# Rezoning Transportation Analysis

Petition Number: #2022-079

Date	Description
11-28-2022	First Review (PDM)
12-22-2022	Second Review (DR)

RZ - 200

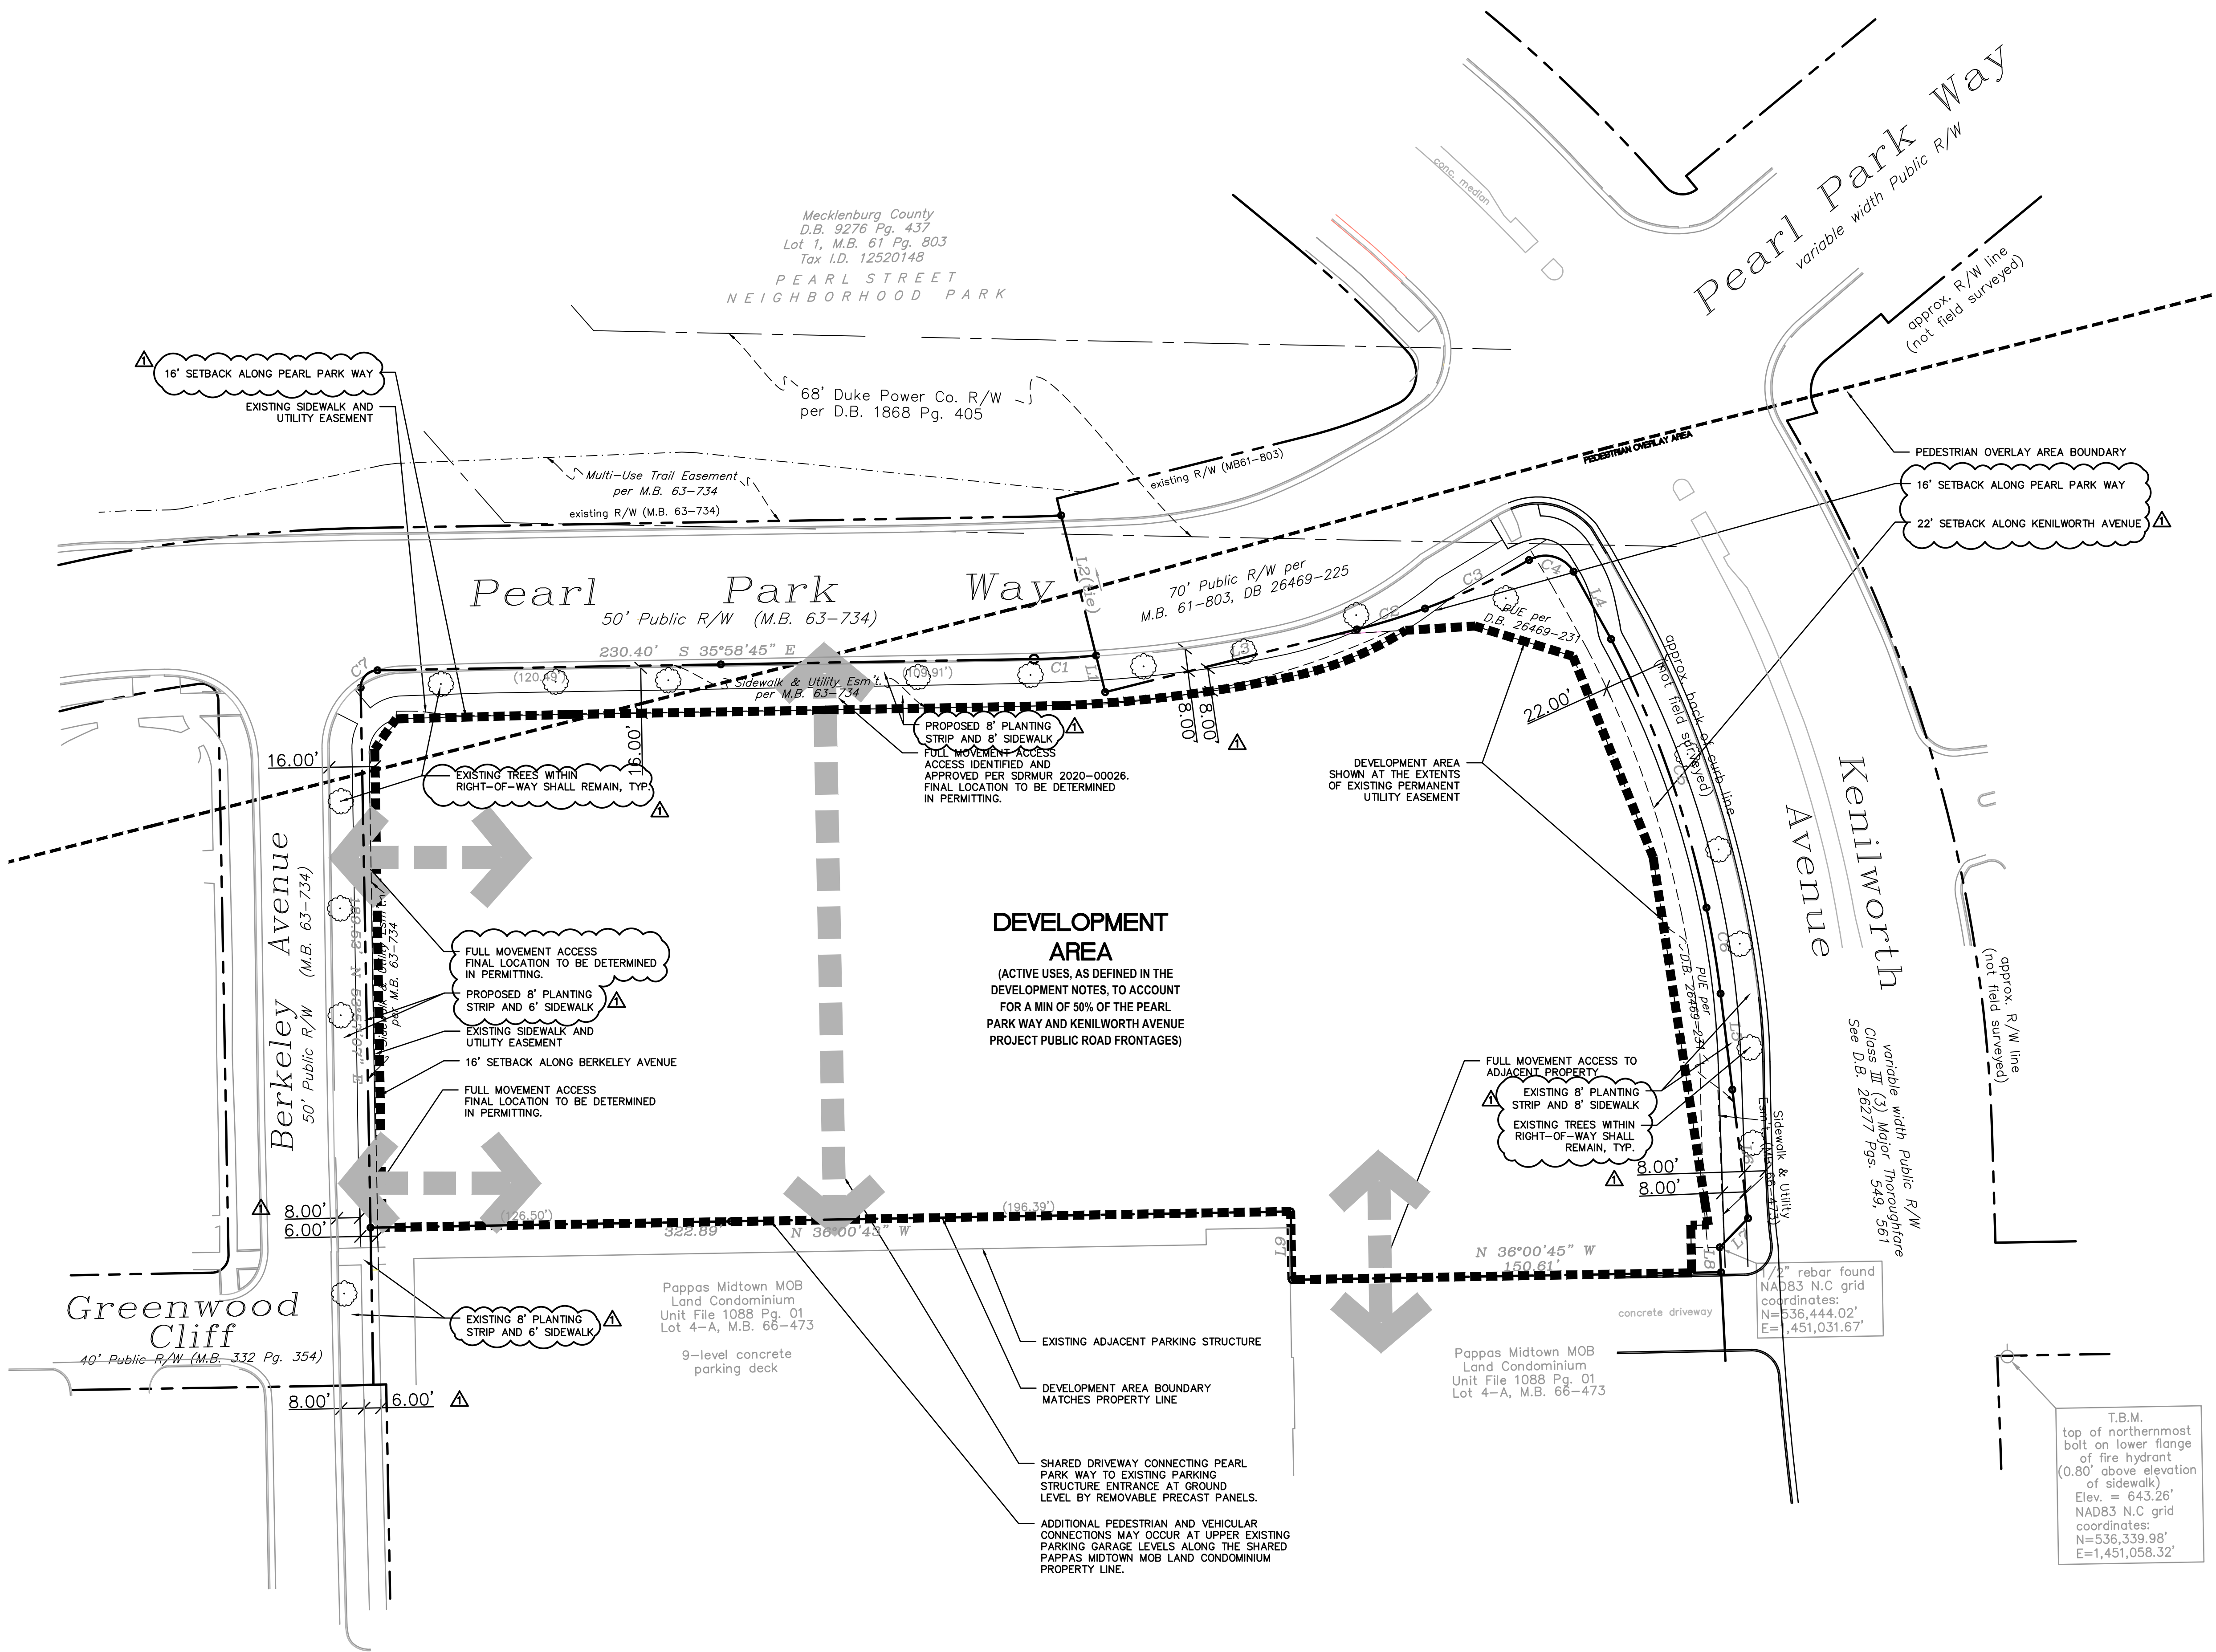
**Outstanding comment 12-22-22:** Label and dimension the curb and gutter from the centerline for each road on the site plan.

6. **New comment 12-22-22:** The two proposed full access driveways on Berkley Avenue do not meet the minimum 75-foot corner clearance distance from an unsignalized intersection per the *City of Charlotte Driveway Regulations*. The driveways will either need to be consolidated or one of them will be limited to right-in/right-out.
